STATE OF NORTH CAROLINA
DEPARTMENT OF TRANSPORTATION

Addendum No. 1

RE: Contract # C204123
WBS # 41582.3.1
FEDERAL-AID NO. STP-0211(021)
Brunswick County (R-5021)
NC-211 FROM SR-1500 (MIDWAY RD) TO NC-87

December 7, 2021 Letting

TIP NO. R-5021	SHEET NO. PMP-4
APPROVED: <i>Andrew D. Klincksiek</i> E3078F84596E44B	
DATE: 10/28/2021	
SEAL 	
DOCUMENT NOT CONSIDERED FINAL UNLESS ALL SIGNATURES COMPLETED

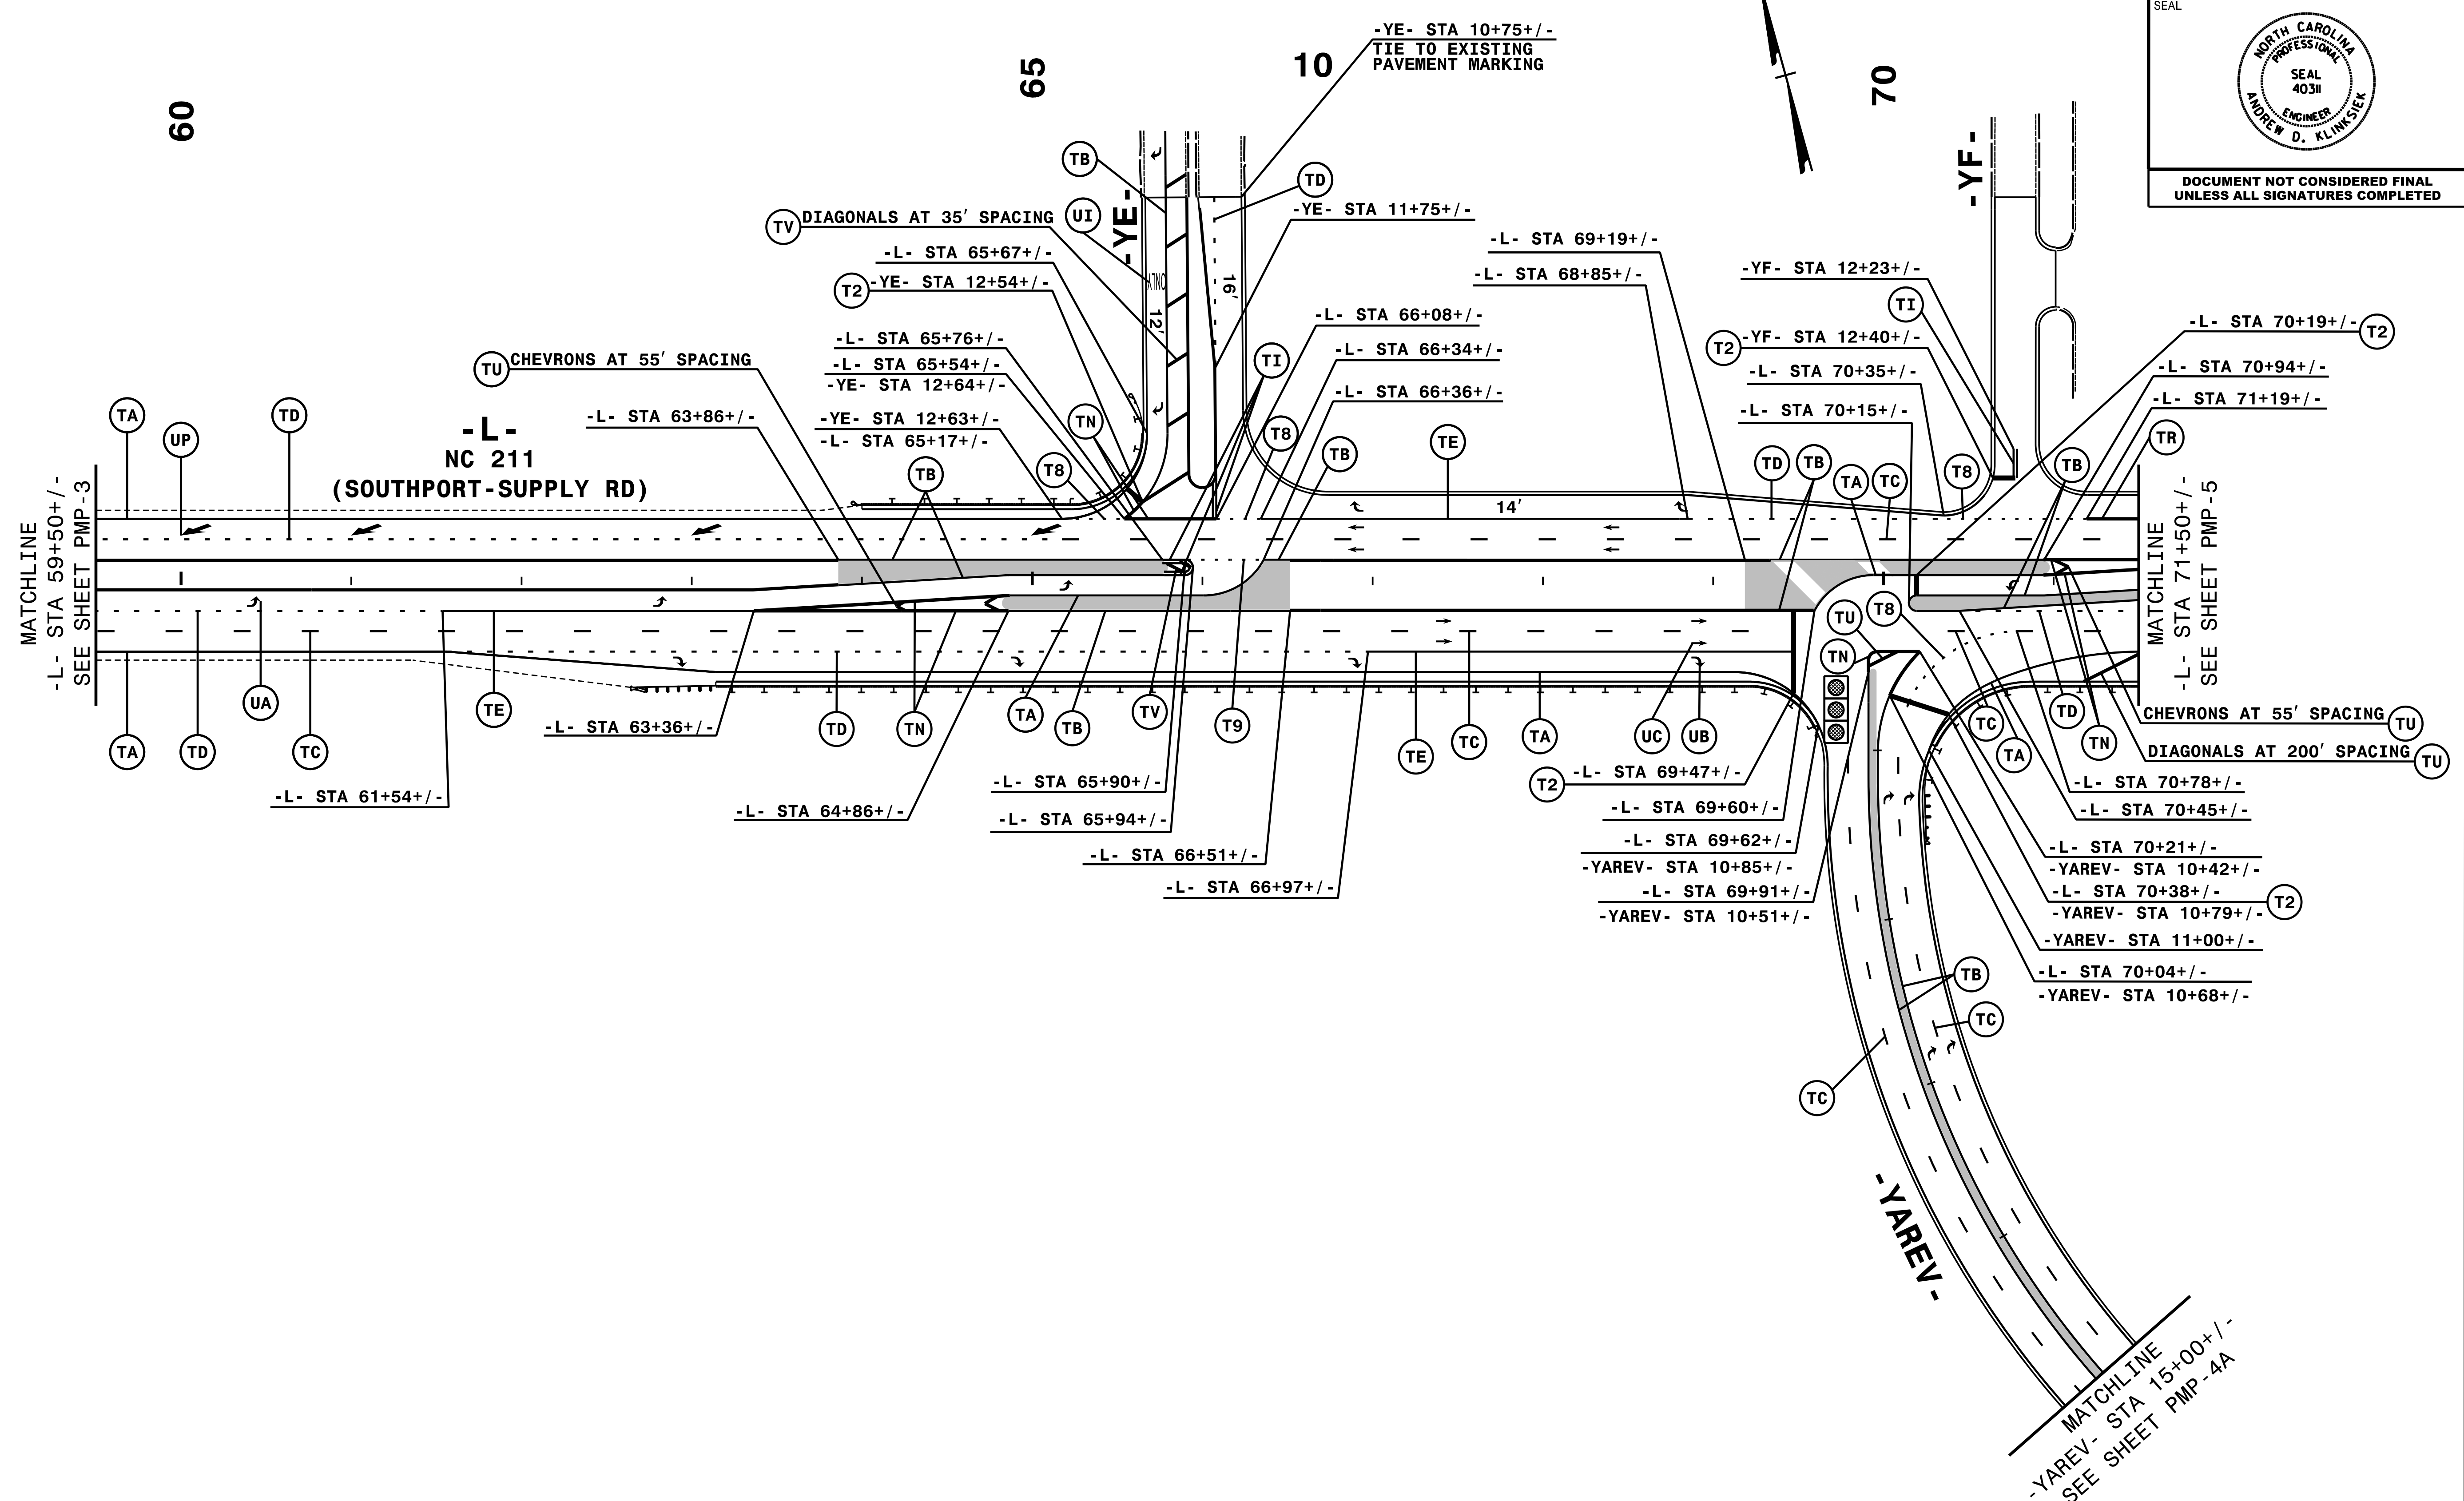
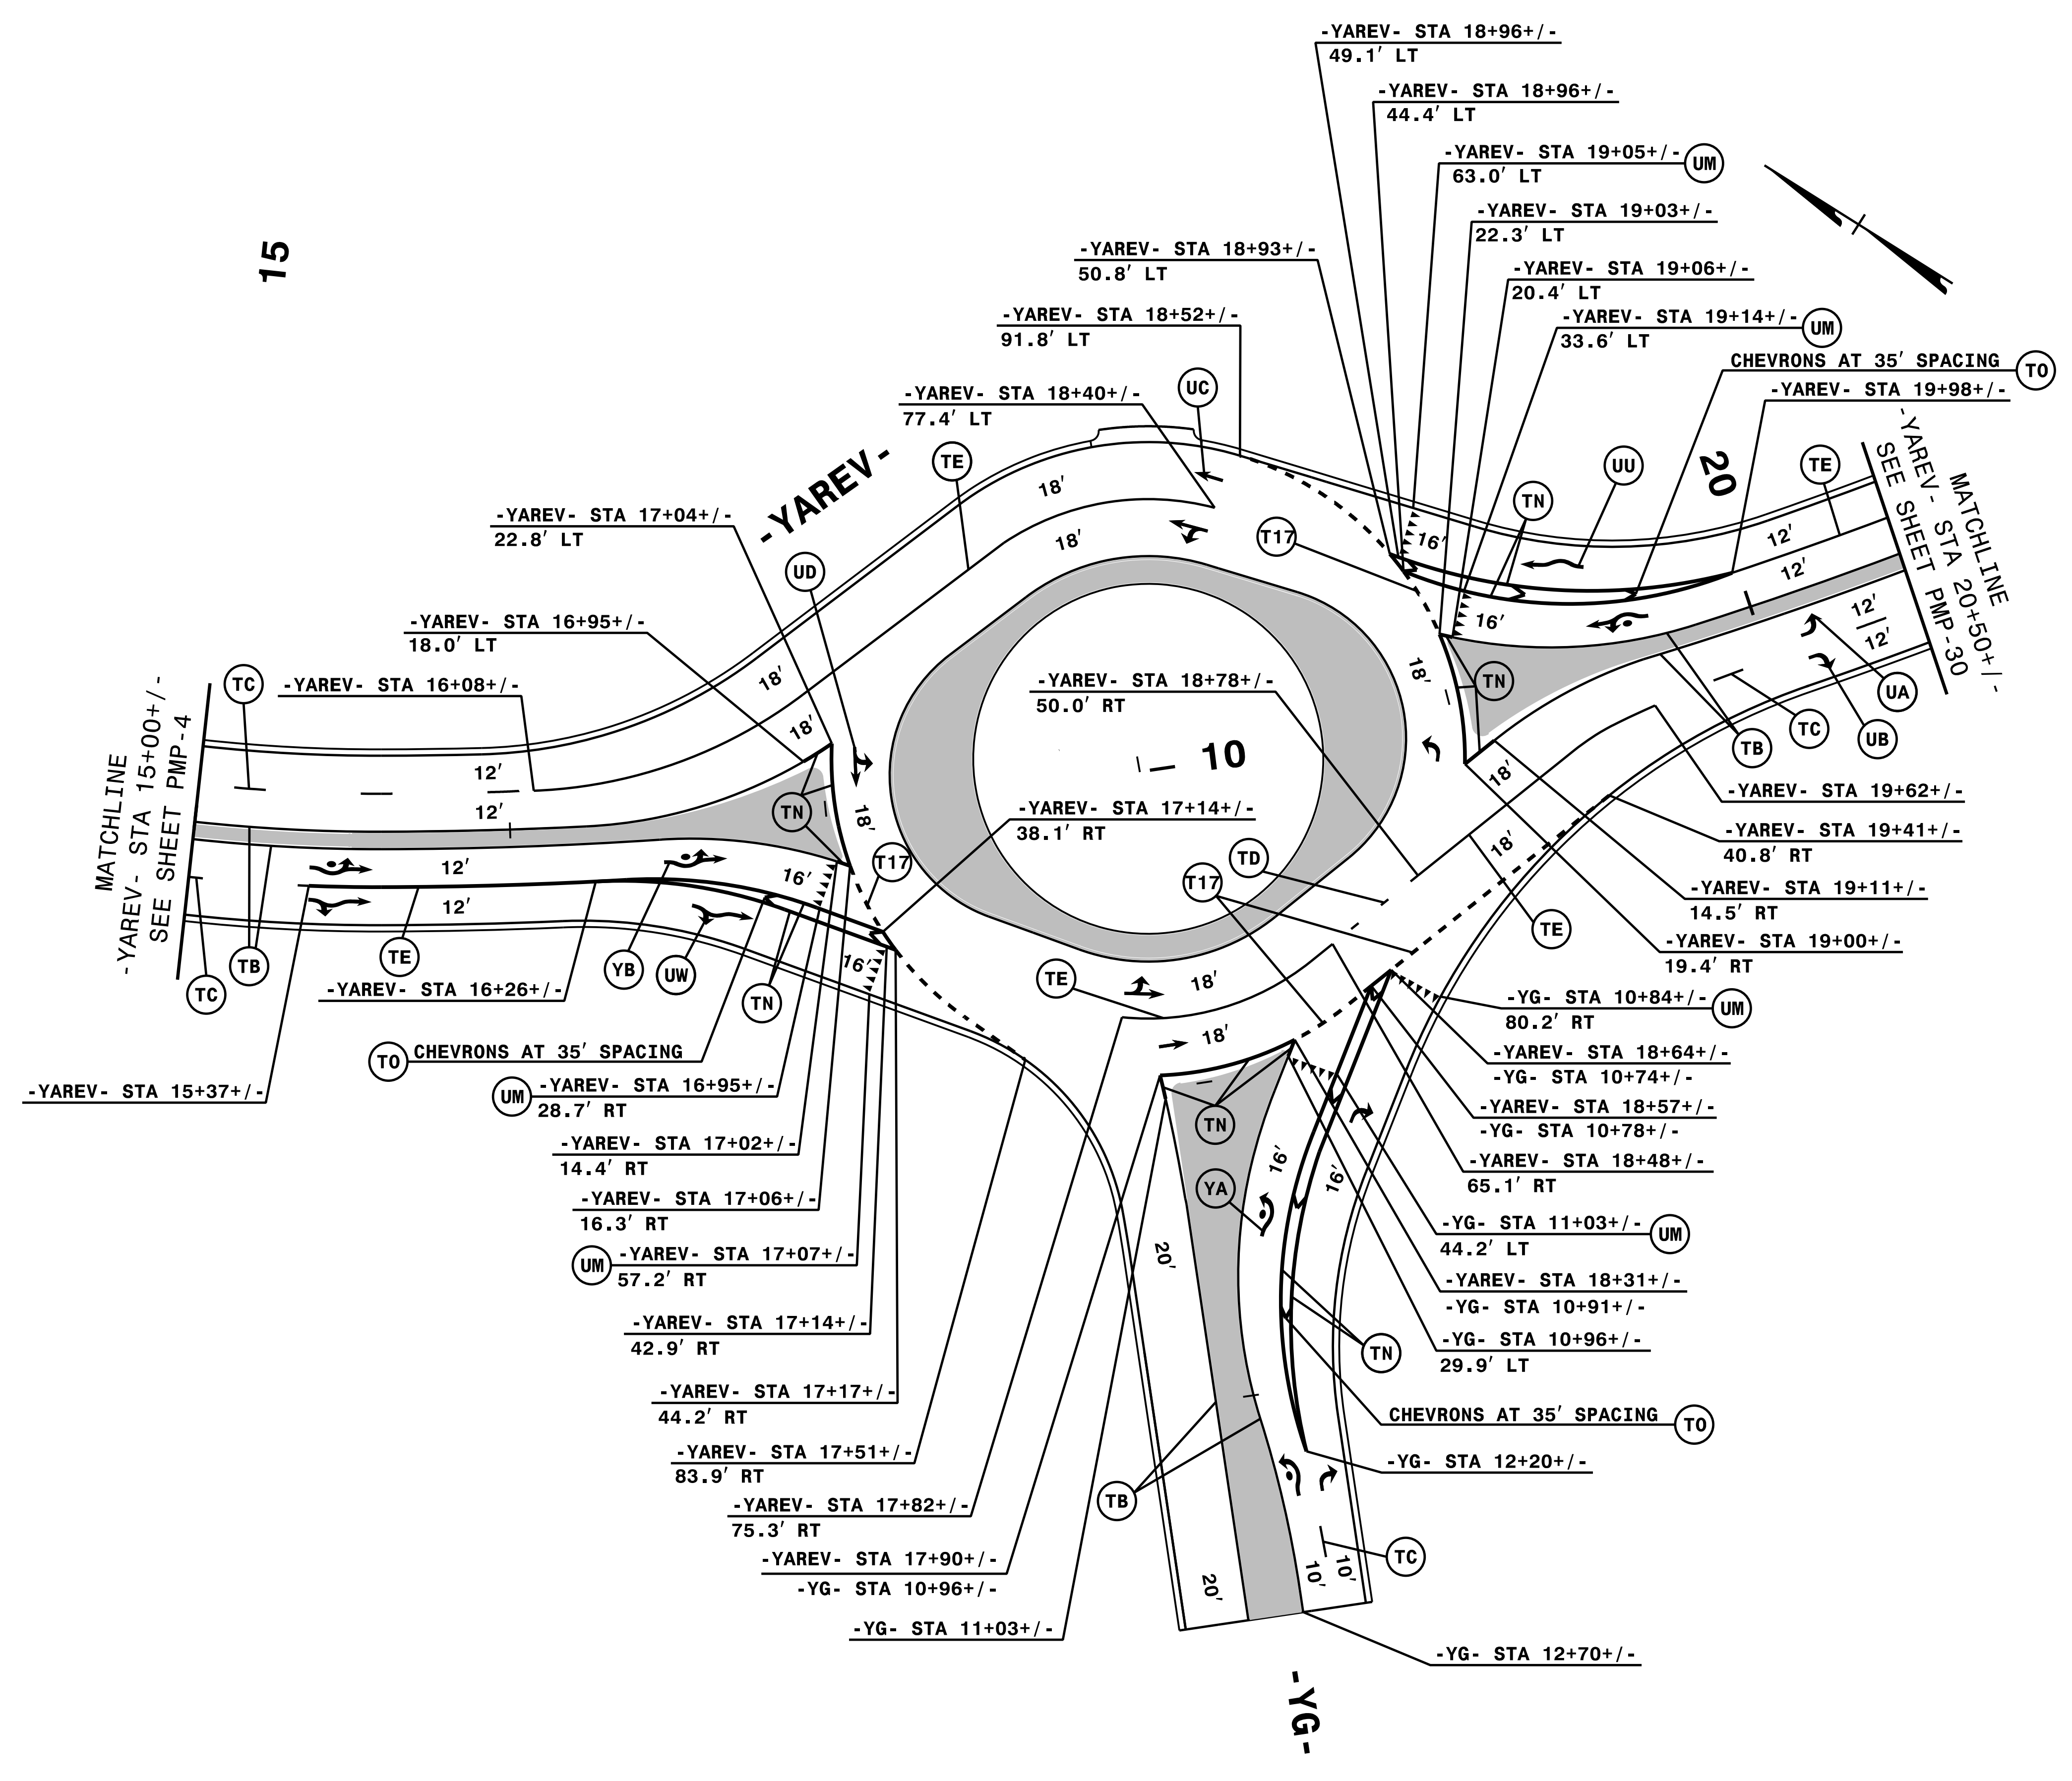
Sheet No.	Revision
PMP-1A	Updated to show additional marking symbols and line types to the Pavement Marking Schedule.
PMP-1B (NEW)	Added to show the addition of sheet PMP-4A on the key sheet.
PMP-4	Updated to show revised pavement markings along -L- and along the new Midway revision alignment -YAREV-.
PMP-4A (NEW)	Added to show the new roundabout along -YAREV-.
PMP-5	Updated to show revised pavement markings along -L-.
PMP-6	Updated to show revised pavement markings along -L-.
PMP-7	Updated to add markings for the westbound turn bay between stations 94+00 to 101+00.
PMP-19	Updated to add markings for the westbound turn bay into -Y9A-.
PMP-20	Updated to add markings for the westbound turn bay into -Y9A-.
PMP-30	Updated to show revised pavement markings along the new Midway revision alignment -YAREV-.
